Master Development Drainage Plan and Preliminary Drainage Report

Peerless Farms
16975 Falcon Hwy
Peyton, CO 80831

PCD File No. SP-21-7

Prepared: November 13th, 2023

K:\COS_LA\196114000 - Peerless Farms\CADD\Exhibits\Drainage Map.dwg

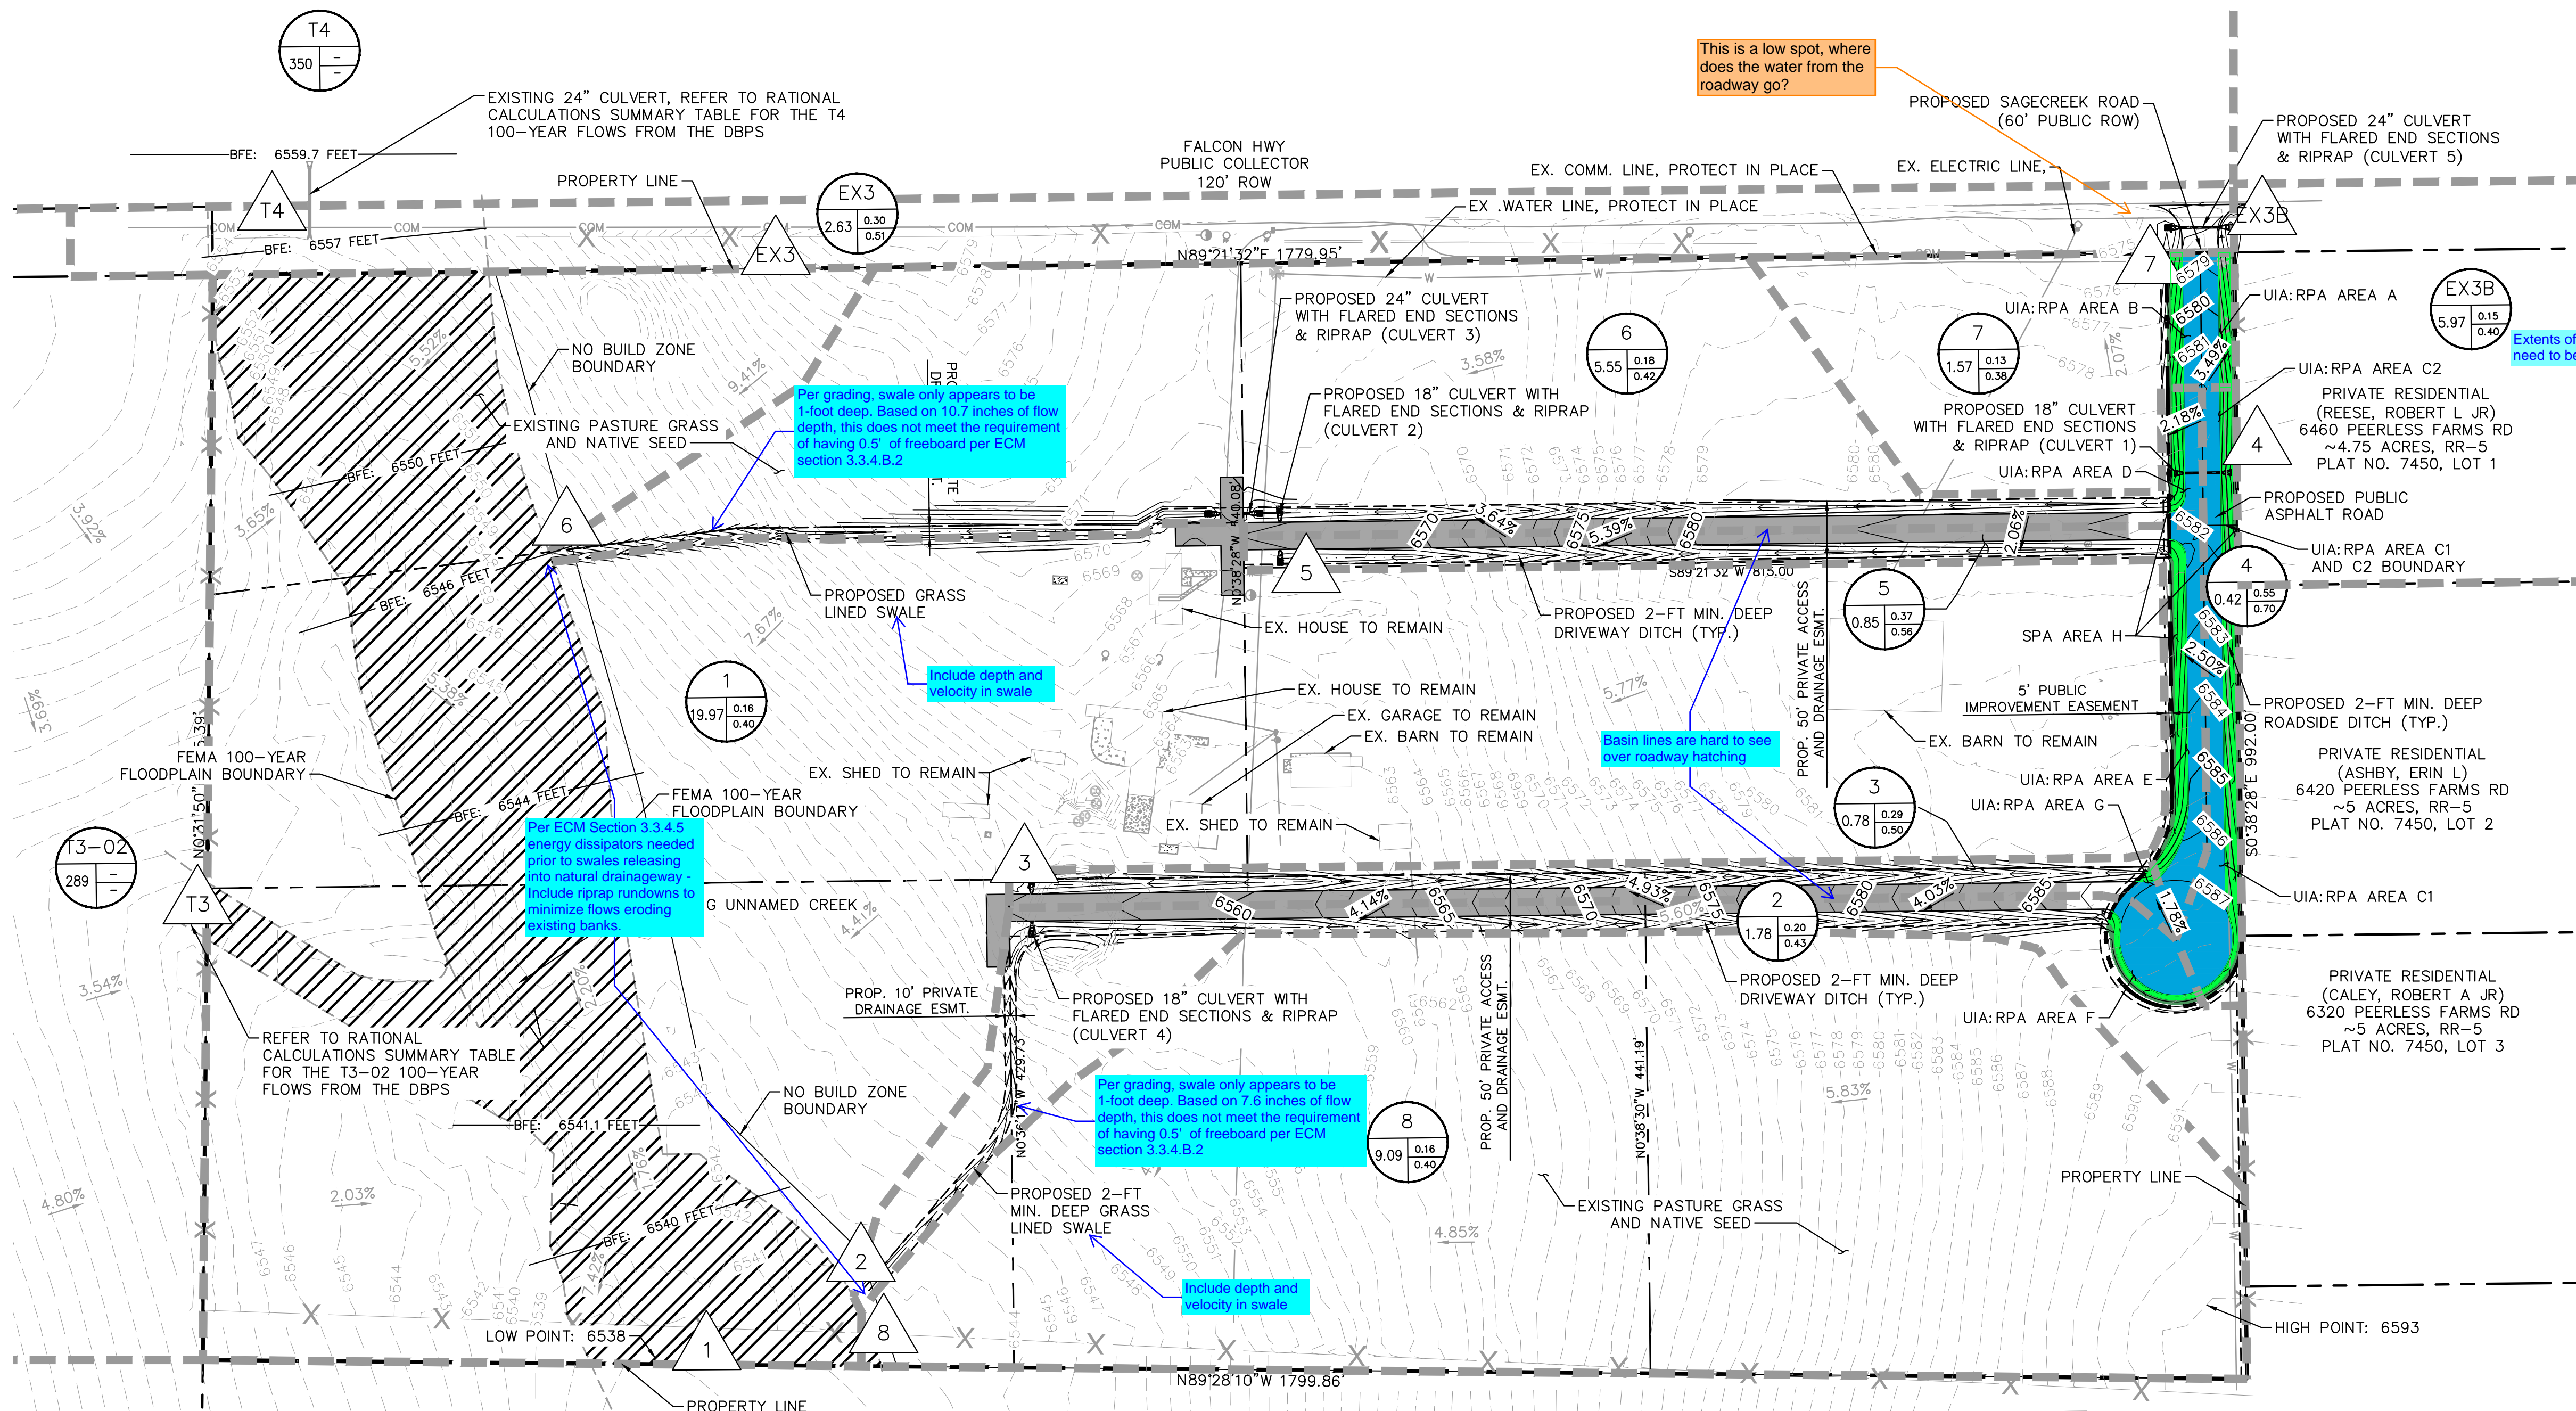
Based on the contours on the CDs, there does not appear to be an existing roadside ditch, but rather a low spot. Clarify, will any increase inflows at the discharge point cause flooding?

KHA Response: The contours as displayed by the surveyed surface do not accurately reflect the condition of the roadside ditch. The ditch's ability to transmit flows has been confirmed by a site visit, and photos showing the subject area of the roadside ditch have been added to Appendix F as figures 9 & 10.
